LOT 8 AKERS ACRES

EL PASO COUNTY, CO
FINAL DRAINAGE REPORT

Submittal Date: Issued for Review July 27, 2018
Revision Date:

Add PCD File No. PPR1848

| 1042 Elkton Drive Colorado Springs, Colorado Phone (719) 531-6200 - Fax (719) 531-6286 E-mail Address: owacivil@mindspring.com | SHEET NO.: C2 | OF 8 SHEETS |

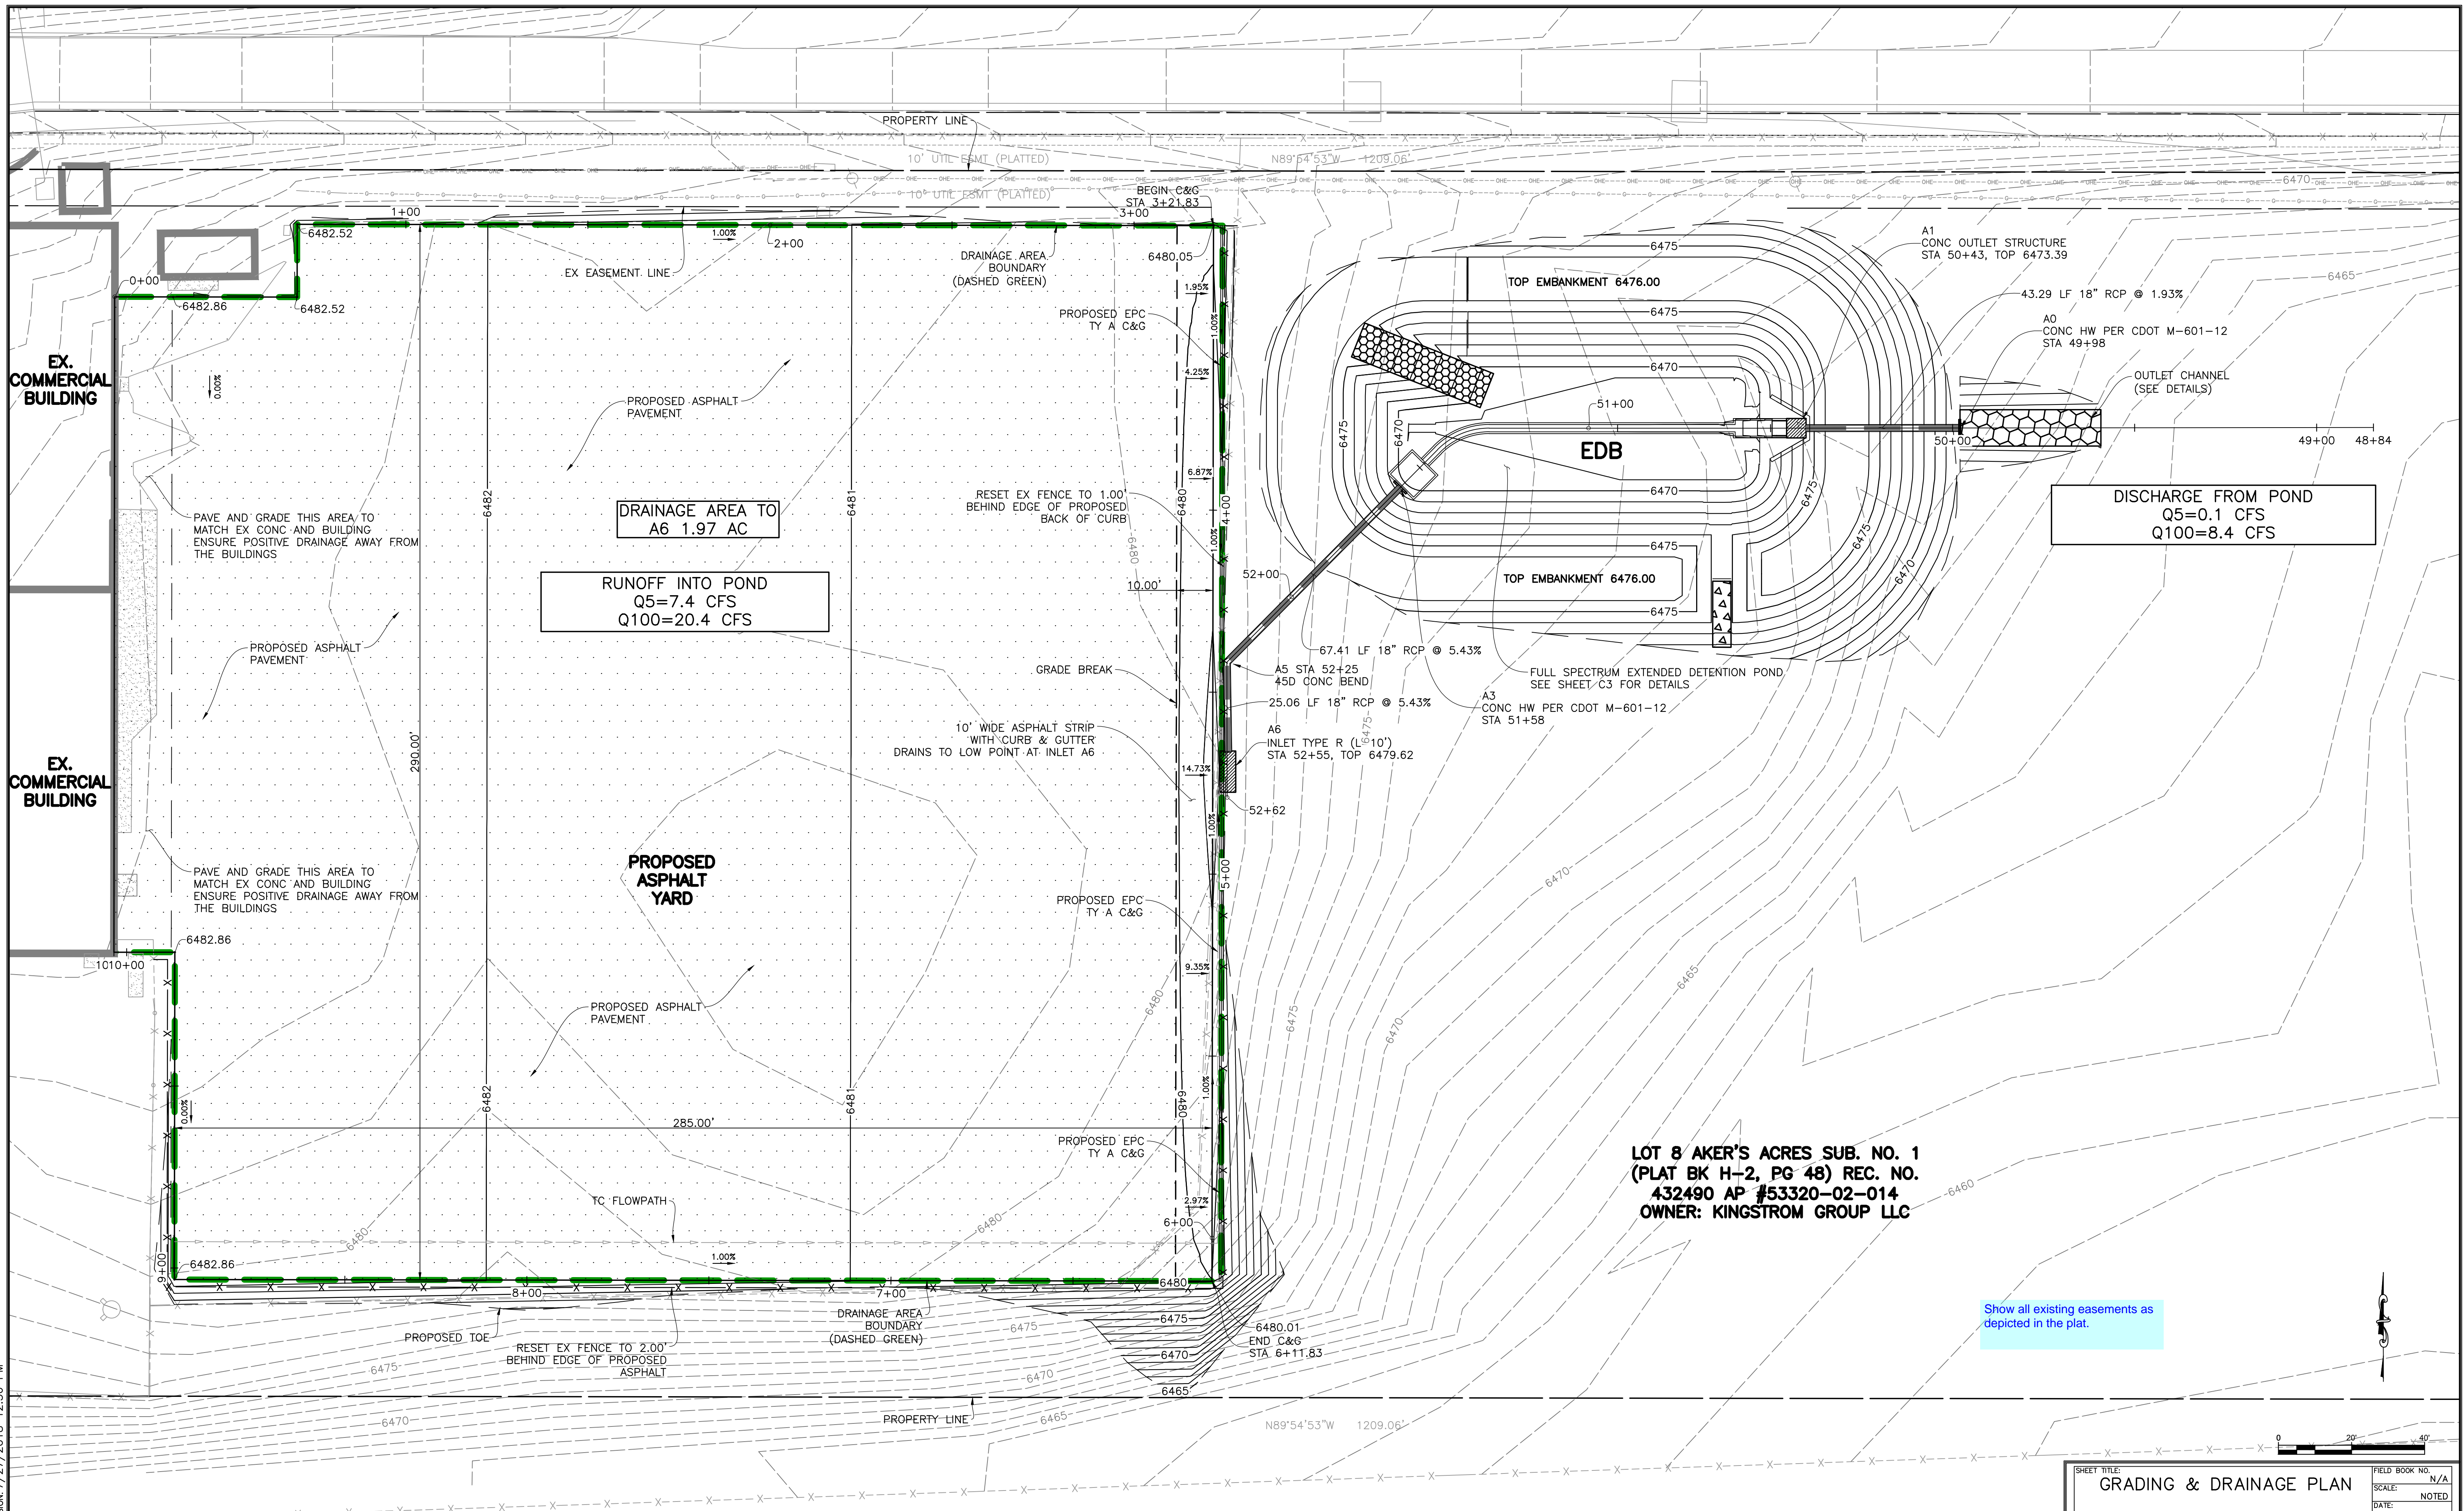
Please provide flow arrows and contour values in this area. Please address flow in the area north of the building as well (both in text and this plan)

Please close the drainage basin boundary line to create an area. Please clarify if this includes the building. Please show if roof drains flow to this direction.

Calculation and narrative indicate an area of 2.07 acres. Revise.

Narrative and calculations indicate 13.5 cfs. Revise.

Calculations indicate a 100yr peak outflow rate of 0.8 cfs. Revise accordingly.

Please address the 100 yr overflow for this inlet. How will the 100yr flow get to the pond?
